REQUEST

Current Zoning: R-8 (single family residential)
Proposed Zoning: UR-1(CD) (urban residential, conditional) & UR-C (CD) (urban residential commercial, conditional)

Approximately .17 acres located at the eastern corner of N. Davidson Street and E. 19th Street in the Optimist Park community.

SUMMARY OF PETITION

PROPOSED SITE PLAN
A-1.1
OF: TWO

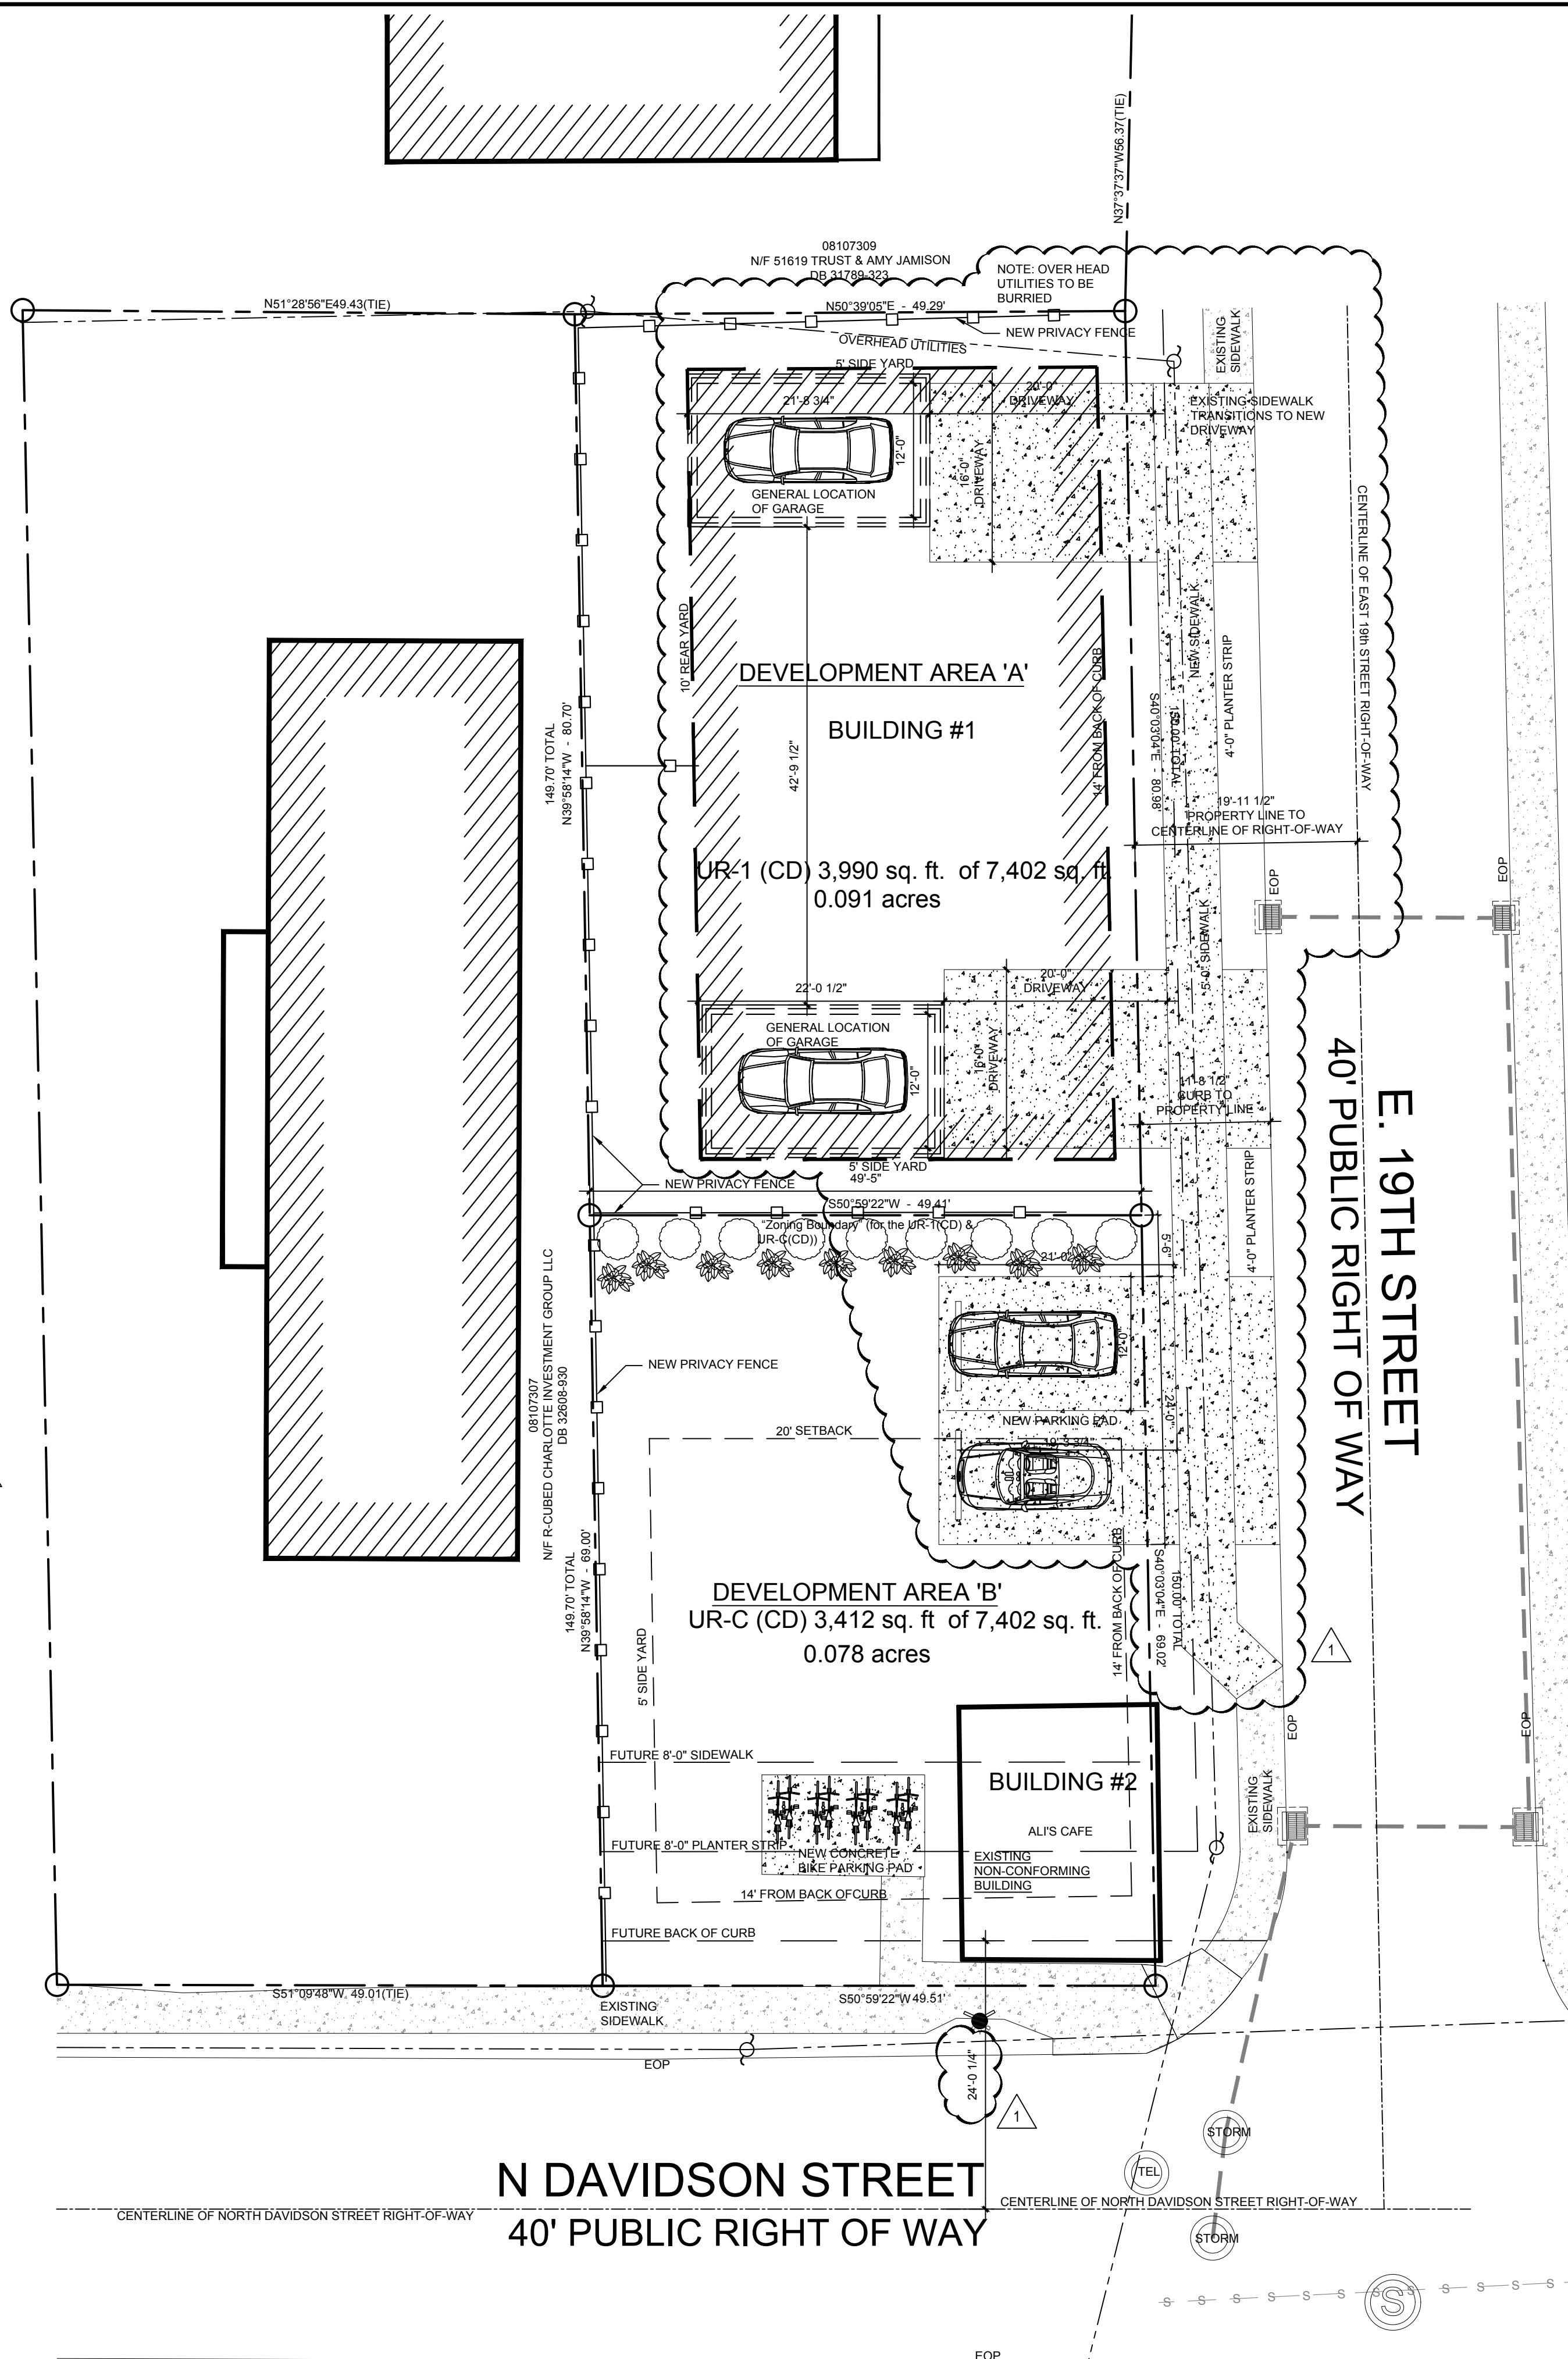
- ~~1. Revise the northern portion of the rezoning boundary (the portion requesting UR-1 designation) into a bubble diagram illustrating buildable footprint only. **ADDRESSED**~~

- ~~2. CDOT is requesting the petitioner update the site plan and conditional notes to show and dimension an 8-foot planting strip and 5-foot sidewalk along 19th Street. **ADDRESSED**~~
- ~~3. The petitioner should revise the site plan to add a note specifying dedication and fee simple conveyance of all rights of way to the City before the site's first building certificate of occupancy is issued. CDOT requests right of way set at 2-foot behind the back of sidewalk where feasible. **ADDRESSED**~~
- ~~4. The future location of curb and gutter is 24' from centerline to back of curb. The site plan should show the curb and gutter labeled and dimensioned from the centerline of each road. **ADDRESSED**~~

- ~~5. In the notes table for Development Area B, revise note 3.D to reflect the commitment only and remove any wording that is reflective of the request to add the note. There is no phasing requested in the plan. **ADDRESSED**~~
- ~~6. Move note 1.F to the Transportation section of the notes; remove bolding and underline formatting. **ADDRESSED**~~
- ~~7. Remove note 3.C. **ADDRESSED**~~
